Environmental Health Consultation Response

To	Harry Chalk
Date	20-05-2026
Planning Ref	M/20/26/PL
Site Description	86 Ancton Way Elmer Middleton-on-sea Bognor Regis West Sussex PO22 6JP
Date of Application	2026-04-09 00:00:00
Category	Application
Recommendation	No Objection No Objection – with conditions Objection Holding Objection

GROUND FLOOR PLAN

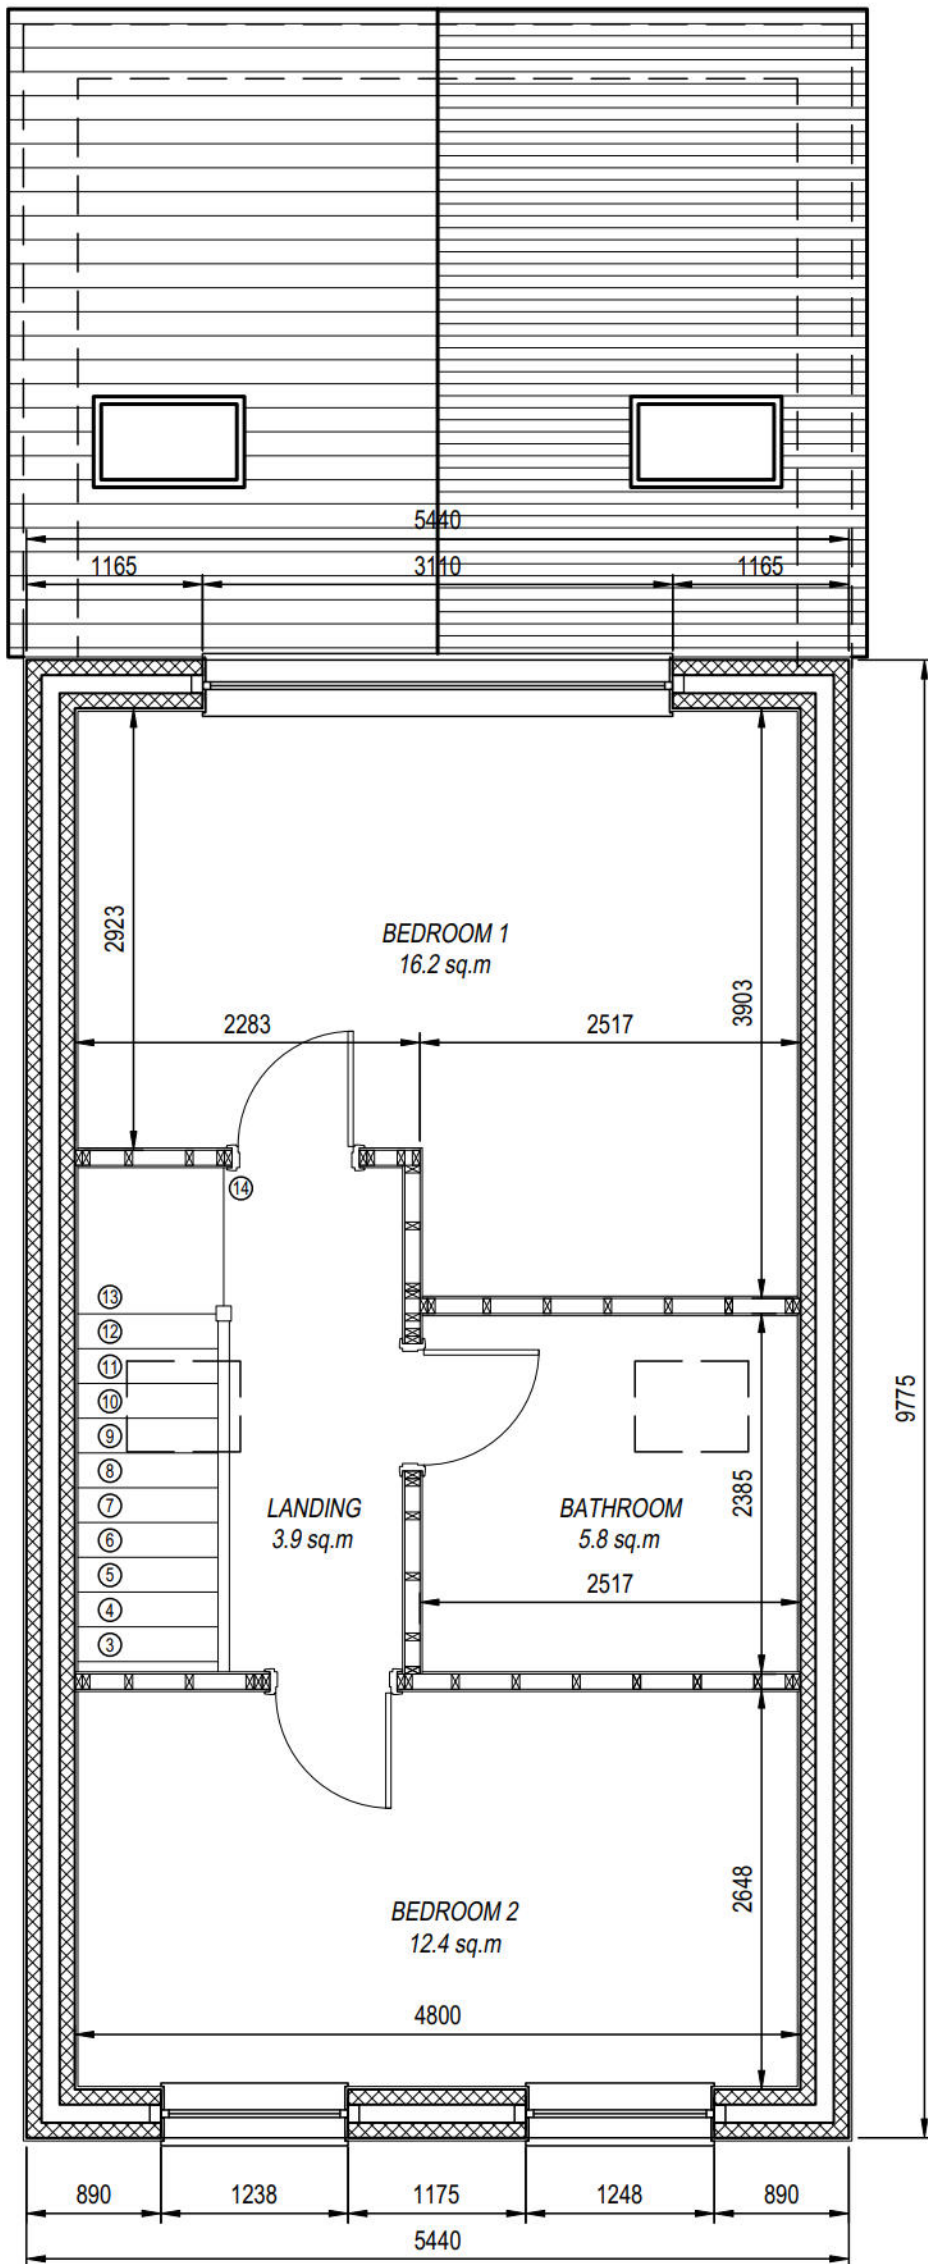
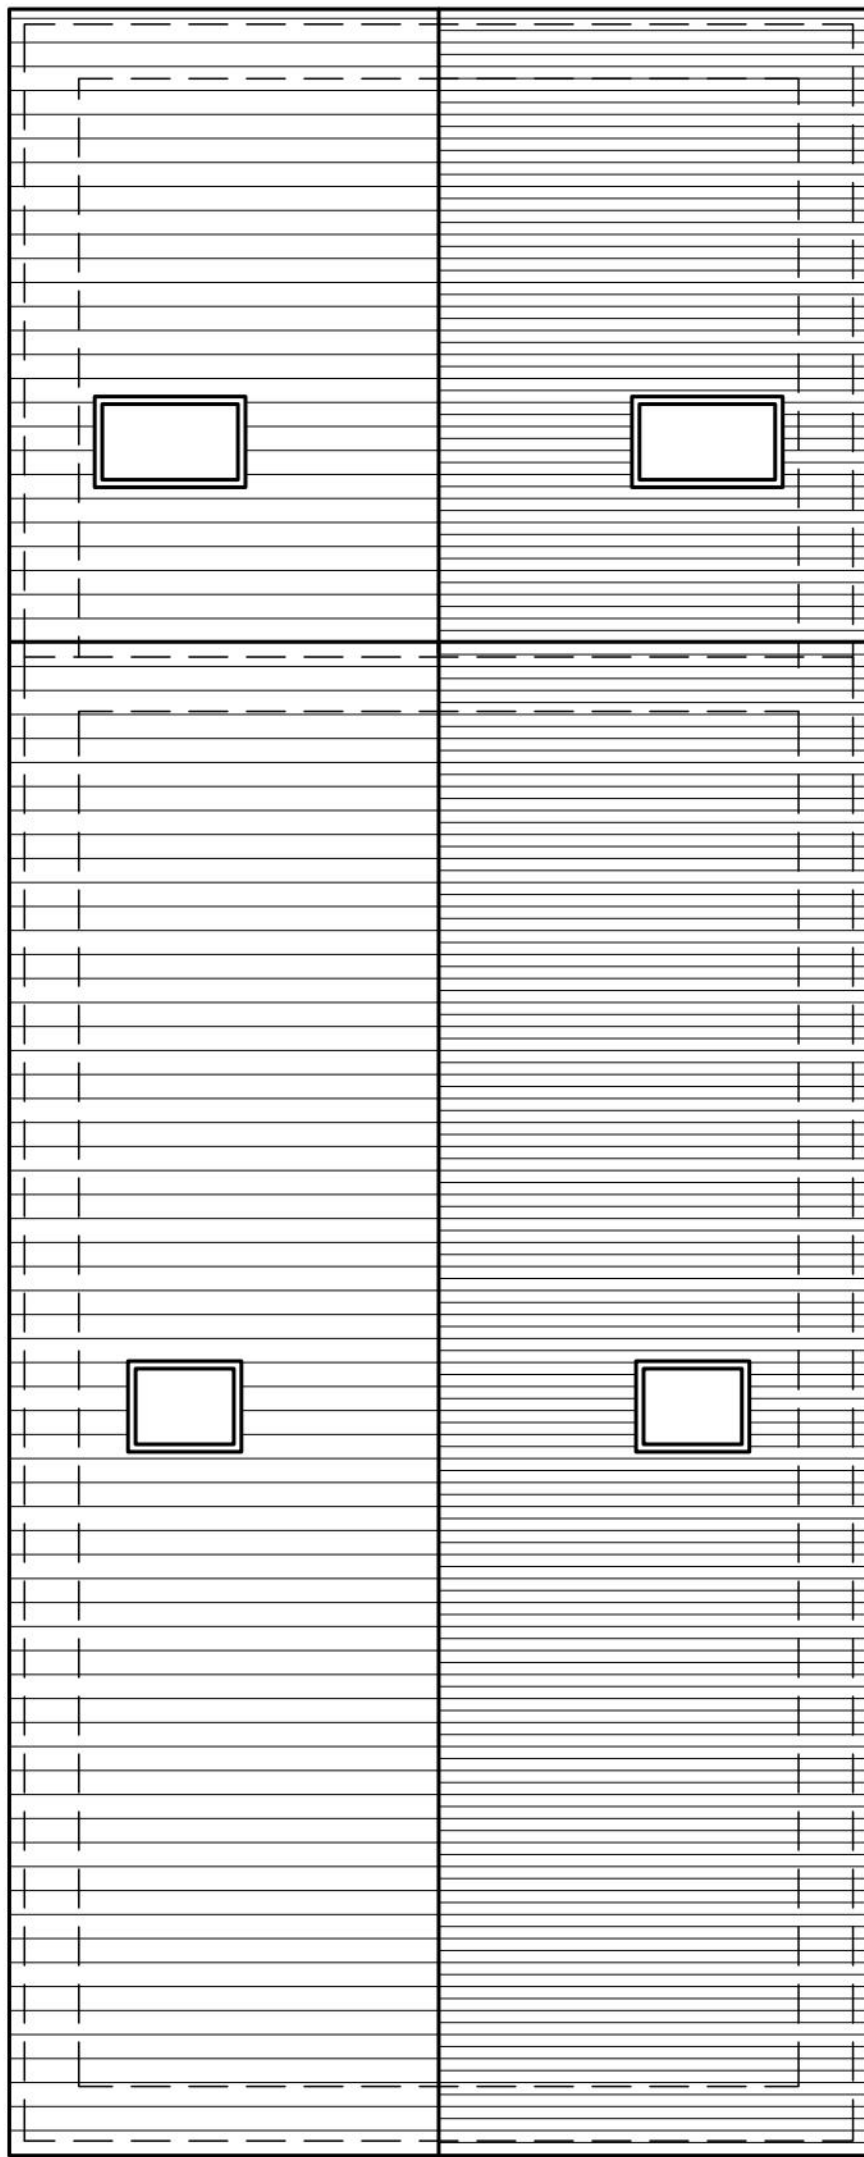
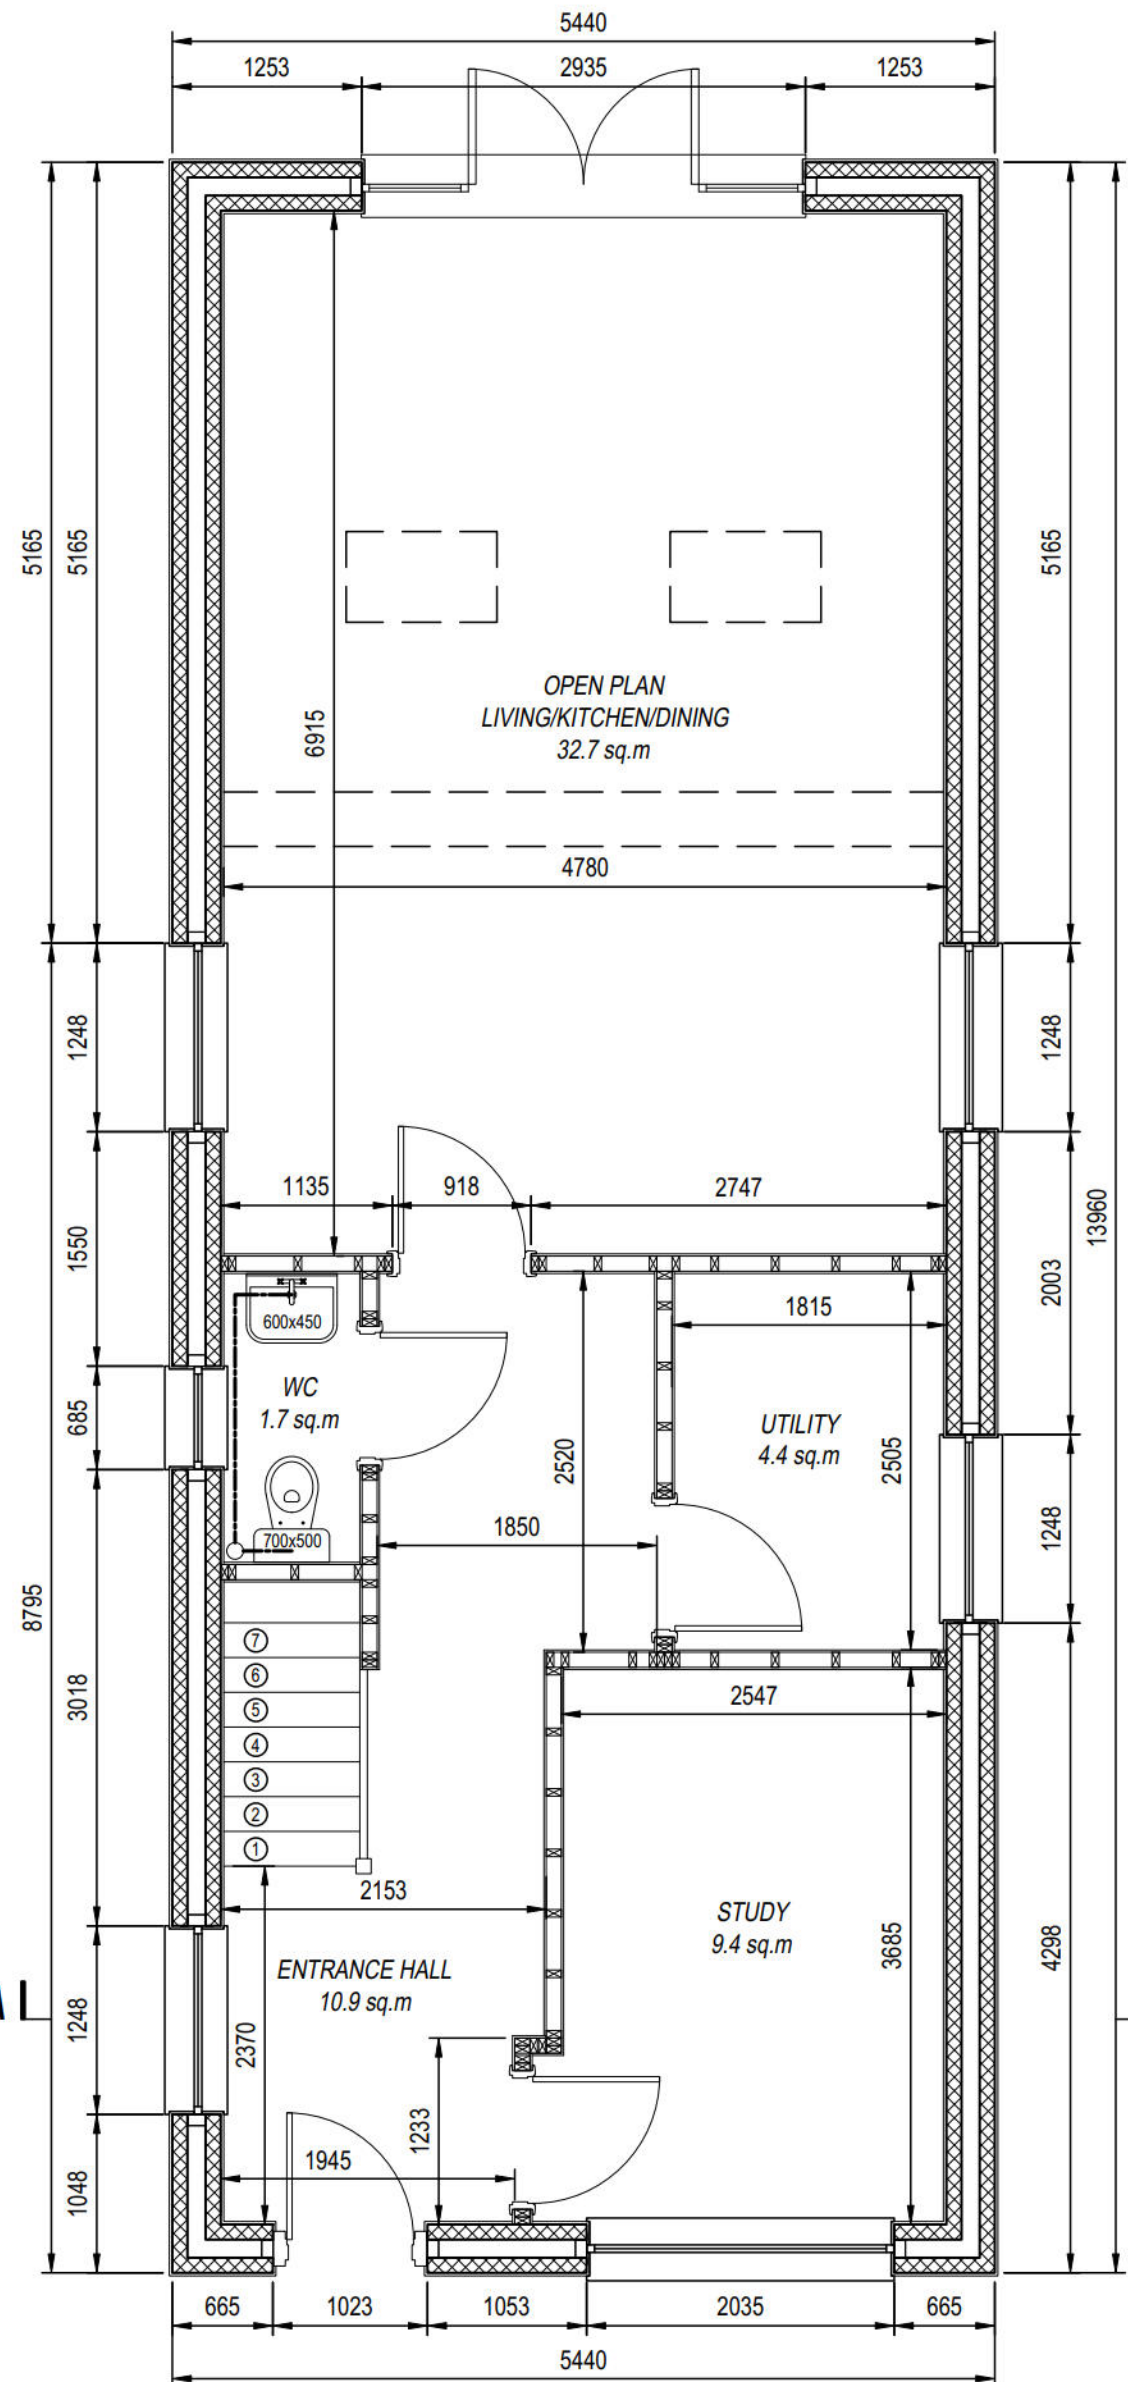
EH Comments: The air source heat pump potentially could cause noise issues as it appears quite close to the neighbours.

Conditions Recommended: An air source heat pump acoustic report shall be submitted to the Local Planning Authority for approval. This report shall show that the approved heat pump complies with the Chartered Institute of Environmental Health and Institute of Acoustic's guidance: 'Air Source Heat Pumps, Professional Advice note 2026'. The sound level emitted from the approved unit will not exceed 37 dB LAeq, 15 Min free field equivalent, 1 m in front of the closest window to a habitable room of a neighbouring property. Where it is not possible to measure at the assessment location, appropriate corrections will be applied to data measured at an alternative location.
[ASHP Practice Guidance Note 2026- Joint IOA CIEH draft \(approved for consultation\) Embargoed version to 2-2-26.pdf](#)
